Your Ref: OWPC20638
Our Ref: BR/254/18/A 26-09-2018
Please ask for:
Amber Willard

Town & Country Planning (Control of Advertisement) (England) Regulations 2007 (as amended)

4 No. non-illuminated advertisements at various locations.
Hothampton Gardens & Surrounding areas Bognor Regis

DRAWING TITLE
GENERAL PROPOSALS

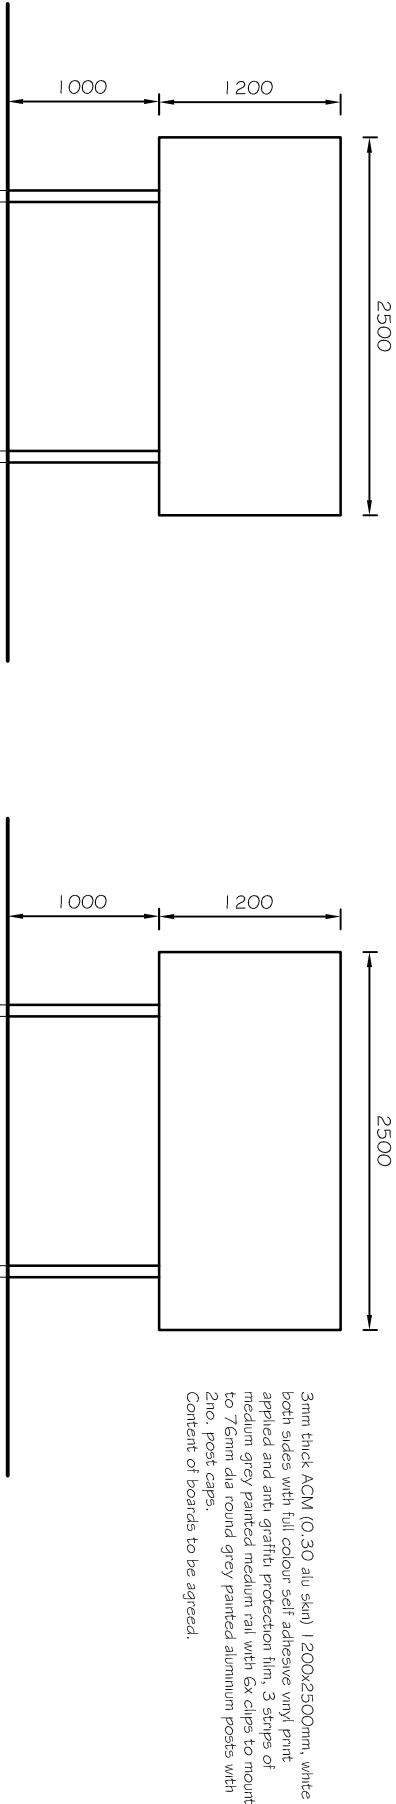
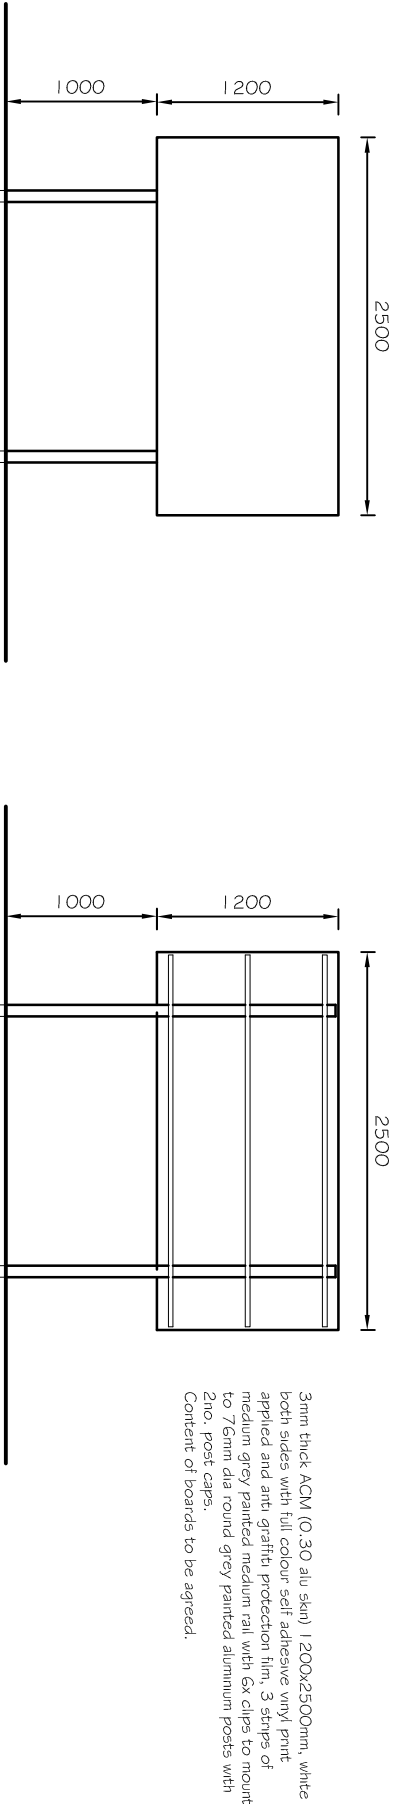
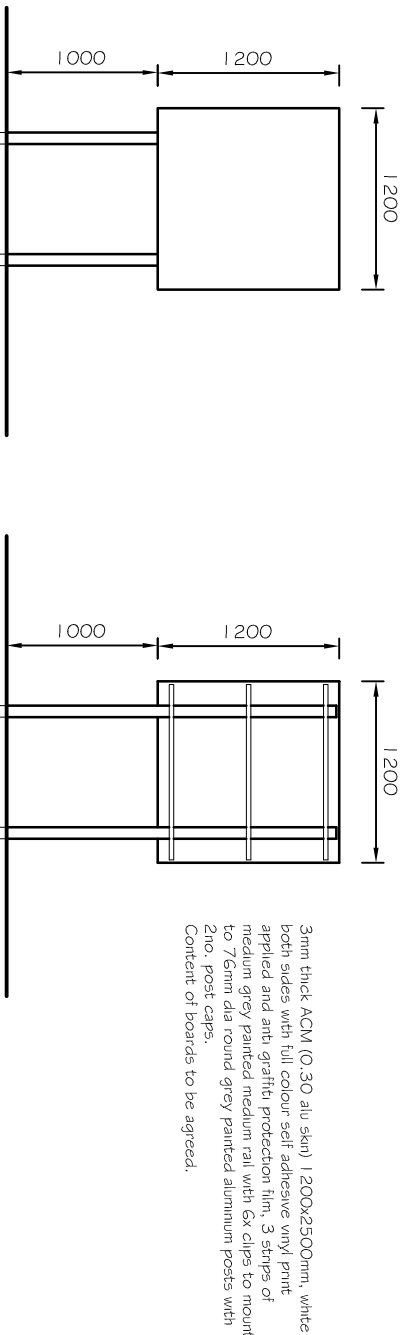
1 BRTC SHOULD have objected on our behalf to the planning application for these signs becasue three of them exceed 2 sq.m, which is the maximum size permitted under "The Town & Country Planning (Control of Advertisements) Regulations 2007" for signs less than 10 metres from the highway.

4 The signs face and are very close to the road and their size could cause an RTA.

DRAWING TITLE
SITE LOCATION AND BLOCK
PLANS

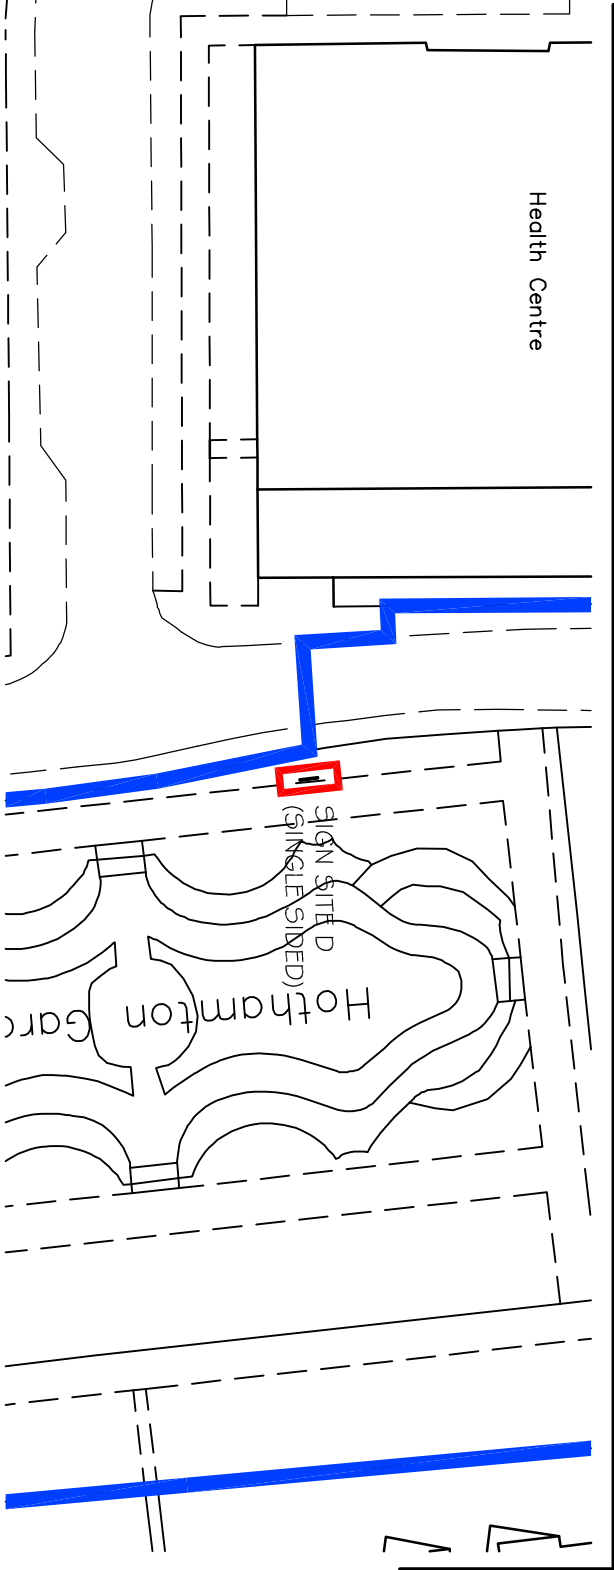
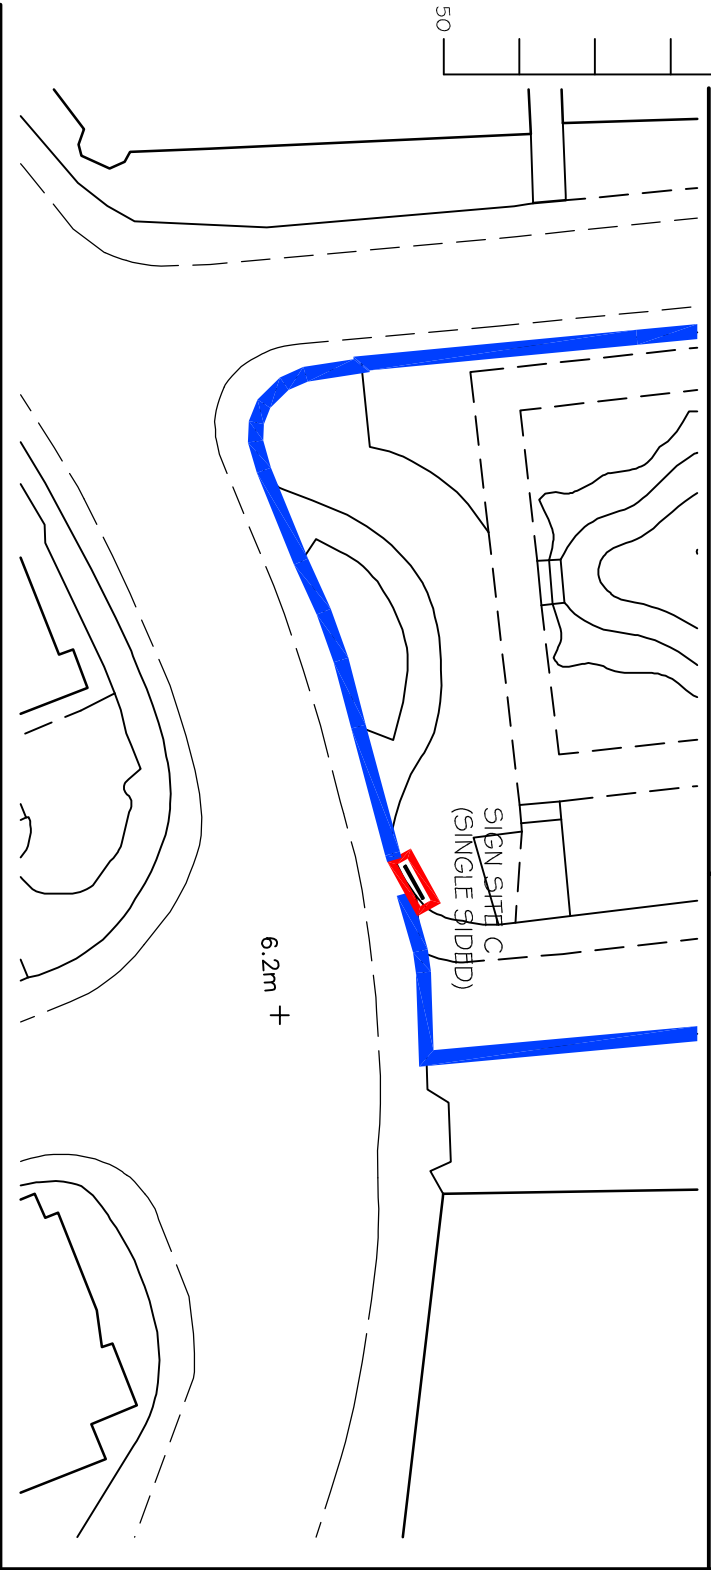
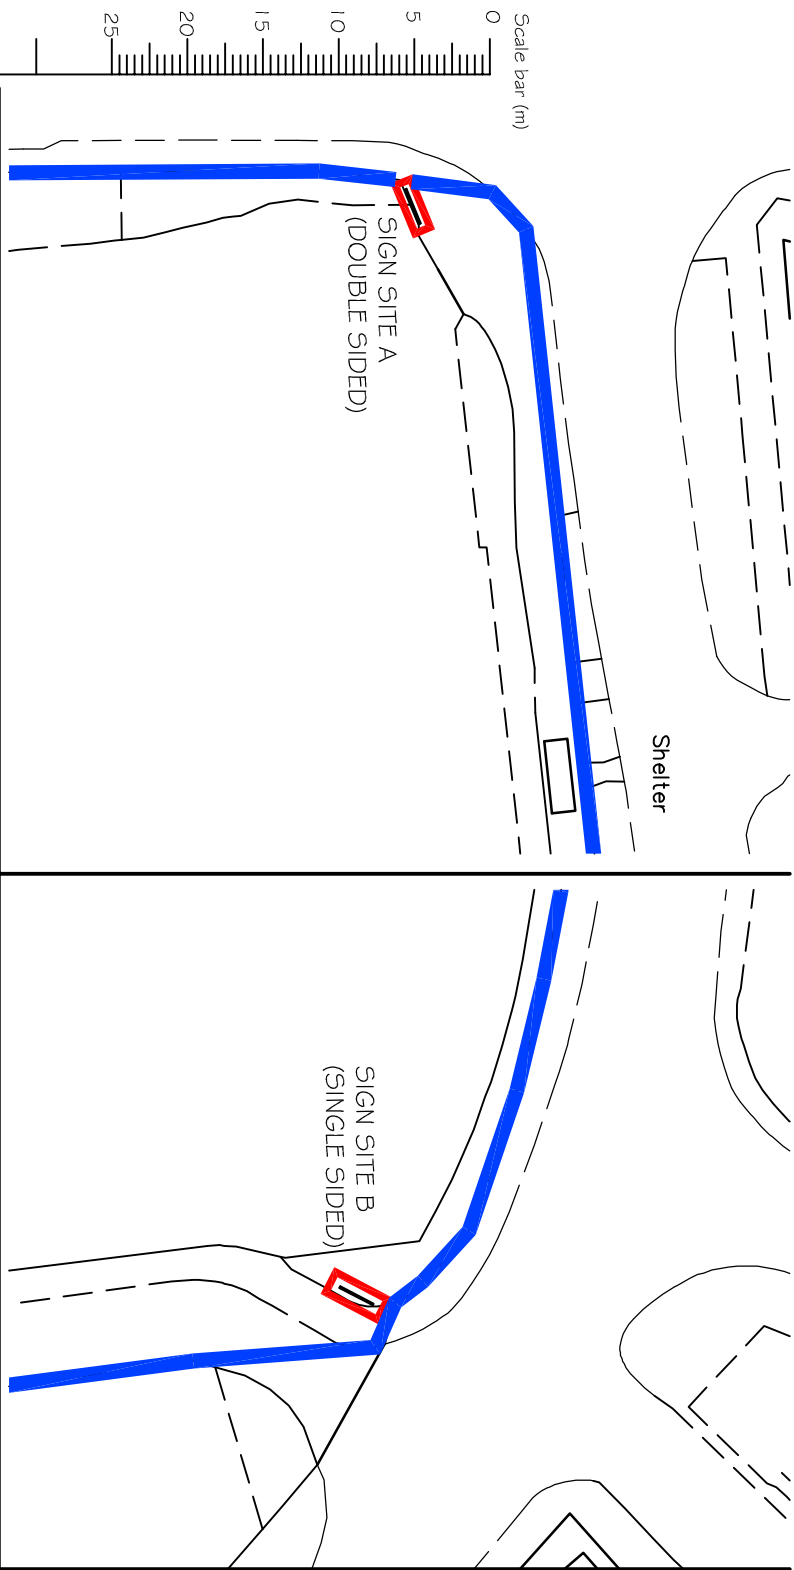
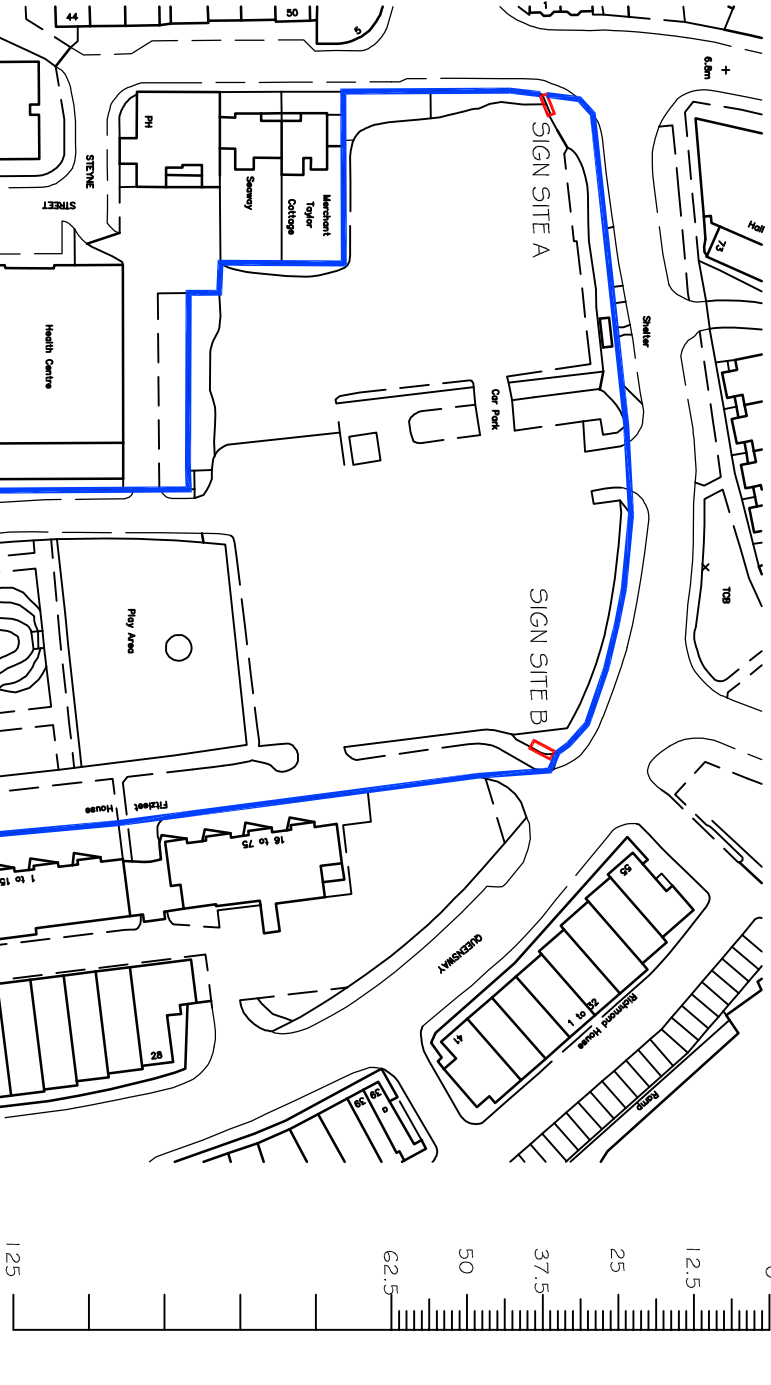
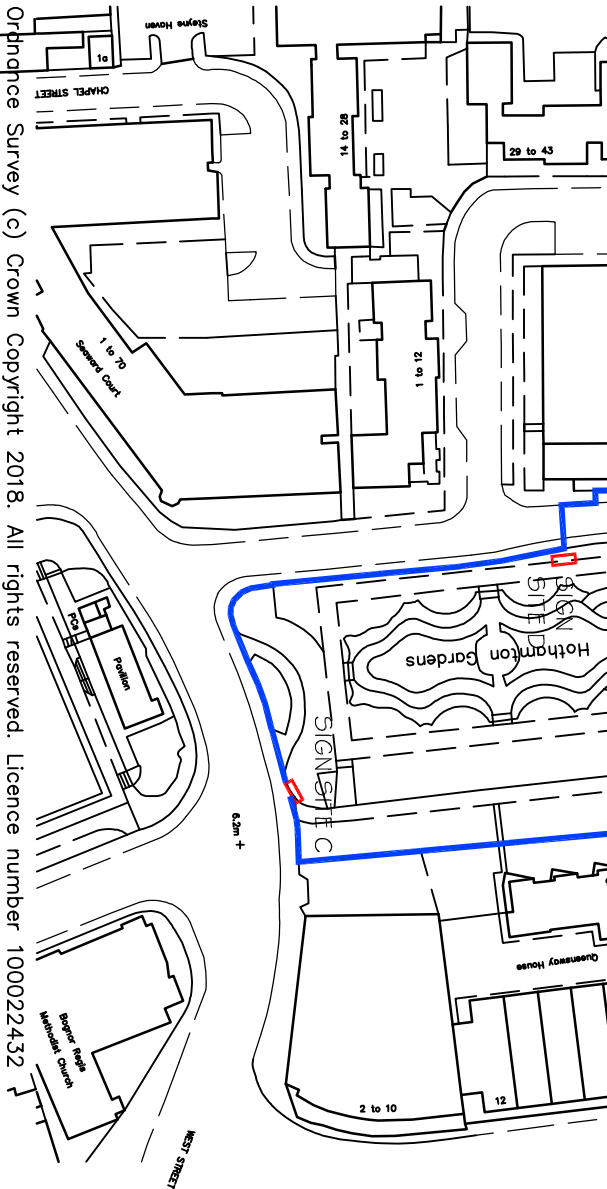
5 The junction on which one of the signs is located is already a dangerous one because, not only is it close to the entrance and exit to this busy Car Park, but is also right next to an extremely busy Stagecoach bus stop. This junction is difficult to negotiate and a large distracting sign could endanger lives.
